Please could we have an extension of time to determine discharge of condition application **A/188/21/DOC** regarding surface water drainage on Land at Dappers Lane, Angmering to **Friday 12th November 2021**.

Thank you for re-consulting us. We have the below comments, which are based upon our previous comments. We do not recommend discharge of condition 18, 19 or 21 at this time.

Application No: A/188/21/DOC
Registered: 3rd September 2021
Site Address: Land at Dappers Lane Angmering Littlehampton
Description of Works: Approval of details reserved by condition imposed under ref A/76/20/PL relating to Condition Nos 17 - existing & proposed ground levels, 18 - surface water drainage, 19 - maintenance & management of surface water drainage, 21 - discharge flows to watercourses and 22 - foul drainage system

Drawing: 20079 - 211 C

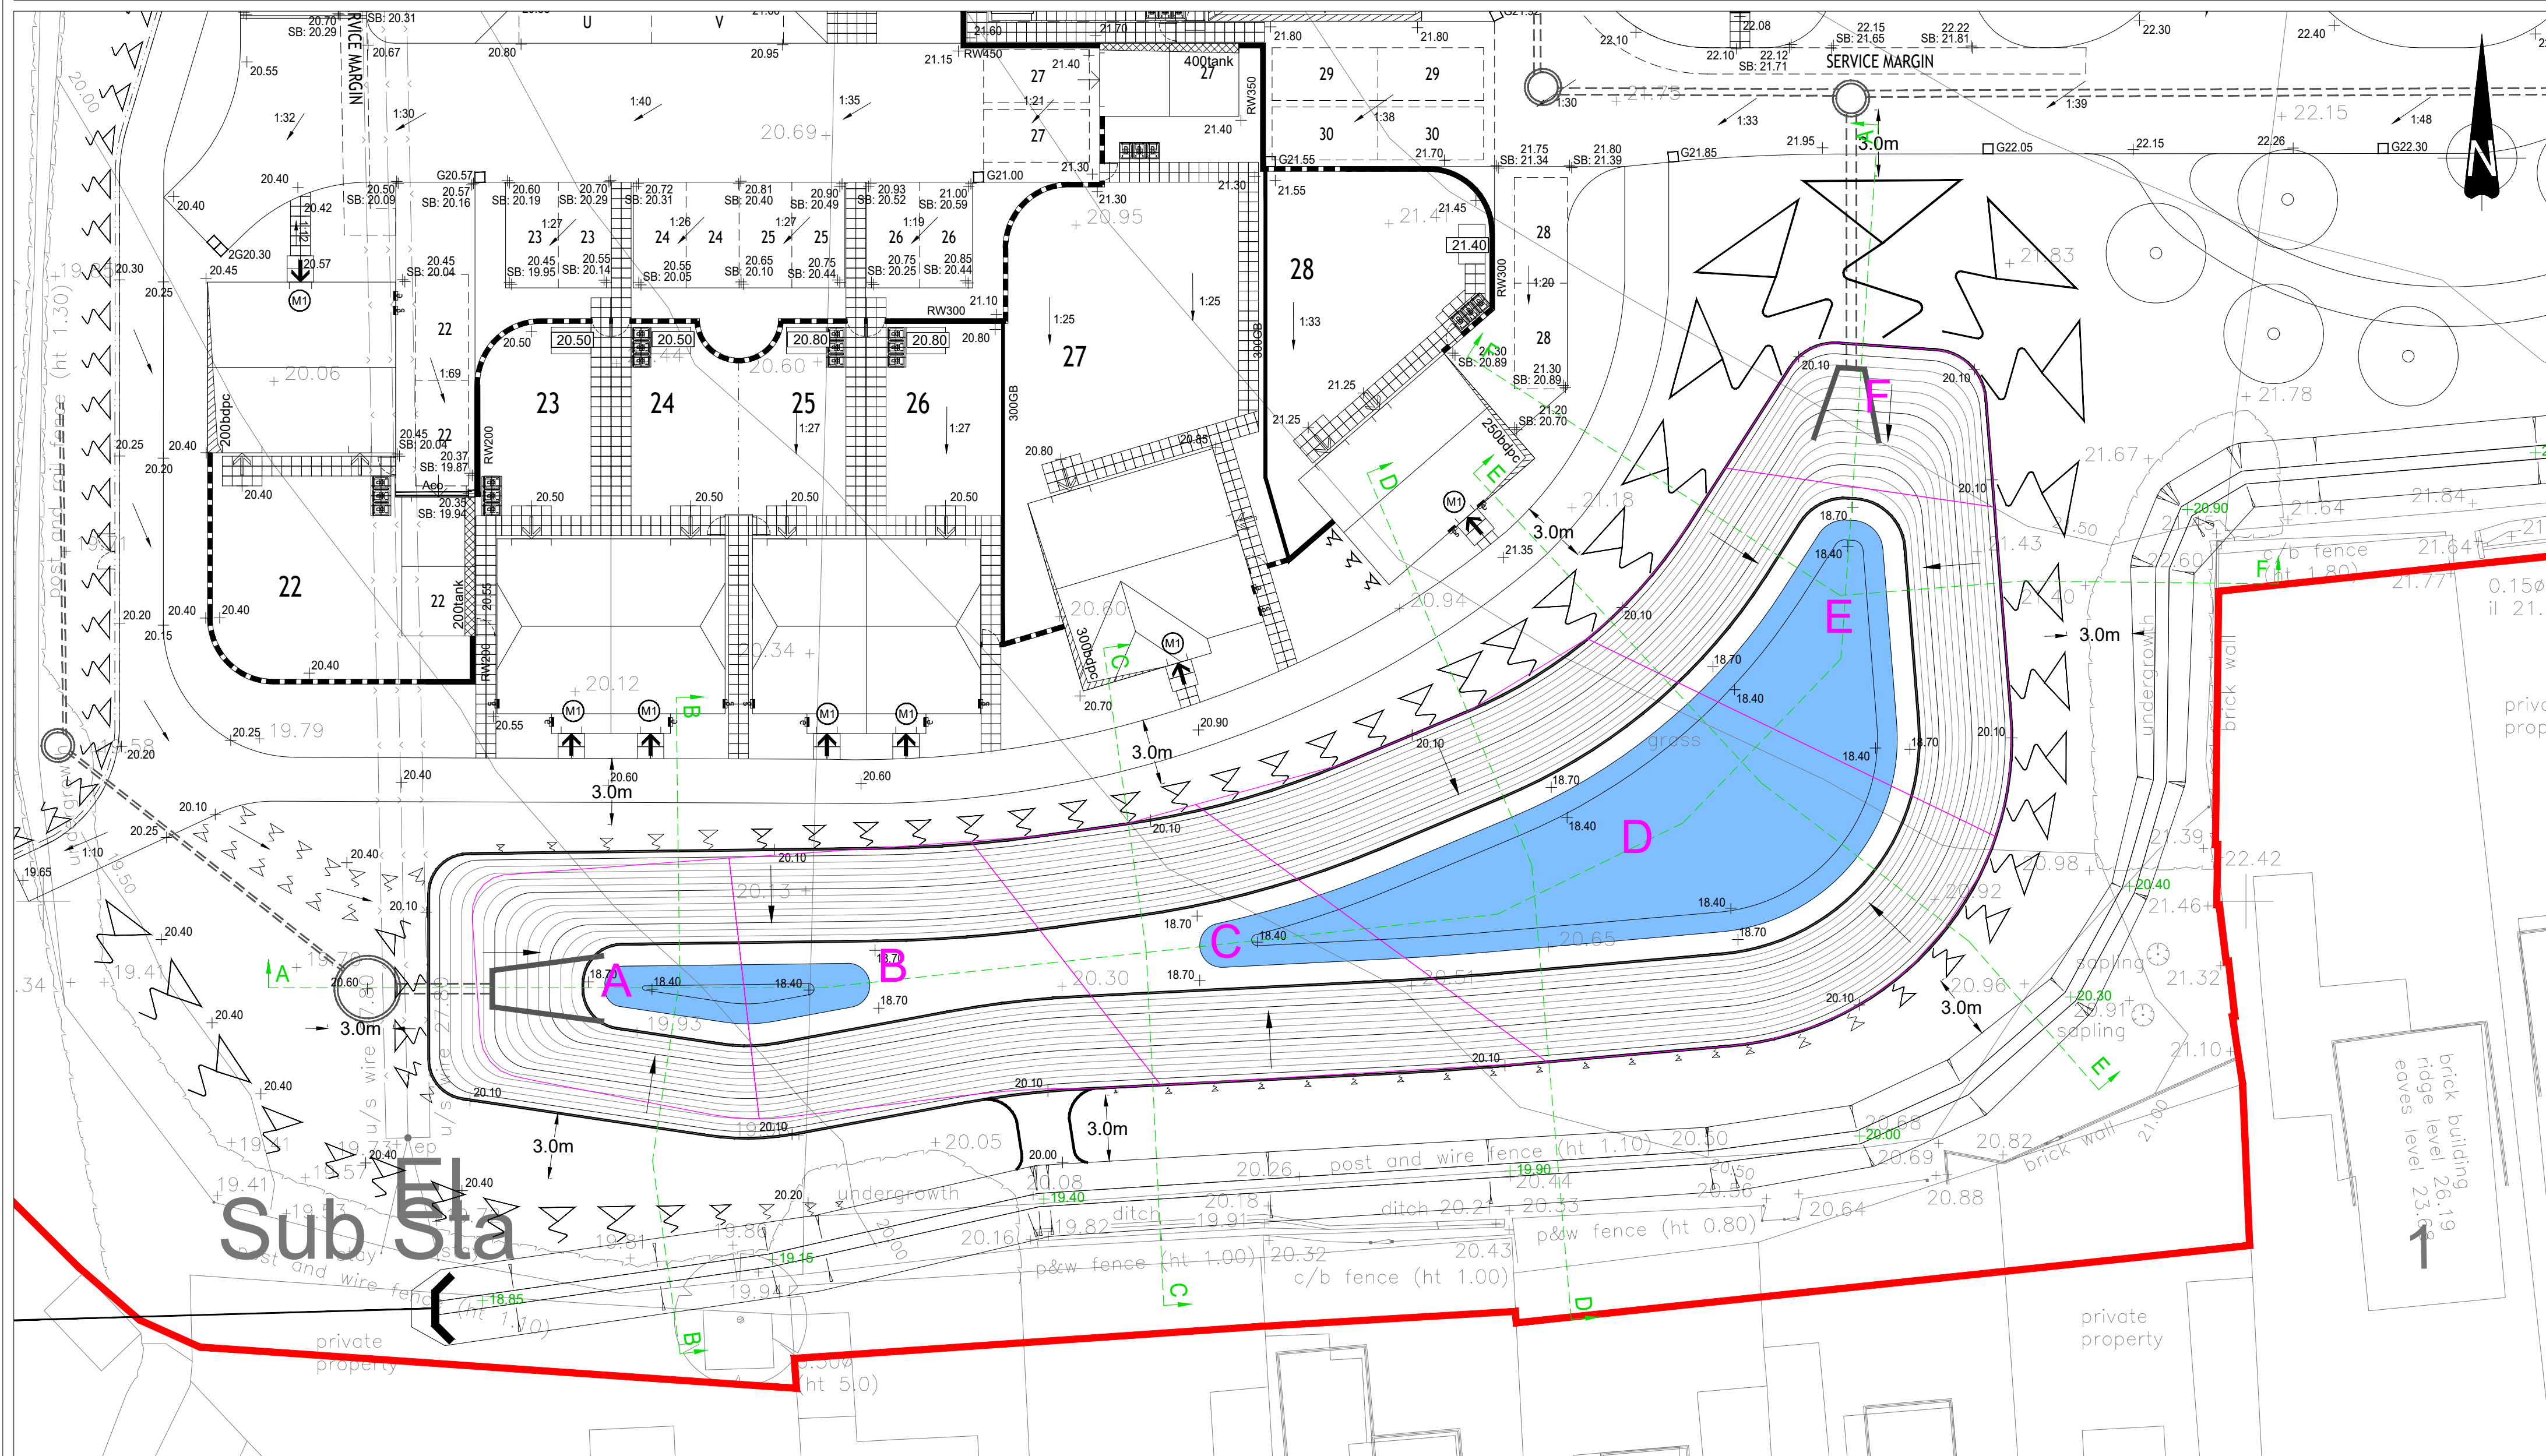
The sketch provided does not clearly show batter extents. However, one of the sump locations is proposed within the proposed ditch extent. There is currently a culvert here. Furthermore, the additional fence line shown for excavation is shown the other side of the ordinary watercourse. As proposals currently stand it is apparent that it will not be possible to excavate the required depth here without bunding the watercourse and temporarily removing a significant length. This is unacceptable.

The method statement provided includes no details of the proposed batter. Assuming this will be a standard 1:3 it is apparent that there is inadequate room on site to construct proposals with just a batter. For example, proposals are for the impermeable liner to be at circa 13.8m AOD, where existing ground levels are 21.5m. This means an excavation depth of 7.7m, which would require 23m horizontal distance, at most there appears to be approximately 12m available here (ignoring the culvert and 6m distance between batter bank and fence line). Further to the south of the basin, excavation depths of 6m are required, with distances of circa 10m available (ignoring the culvert and 6m distance between batter bank and fence line) for the required 18m horizontal distance.

The method statement identifies that at least 4 no. 6 inch pumps will be required to dewater the excavation 24/7. Even if these are silent, they will require generators which could cause a nuisance to nearby residents.
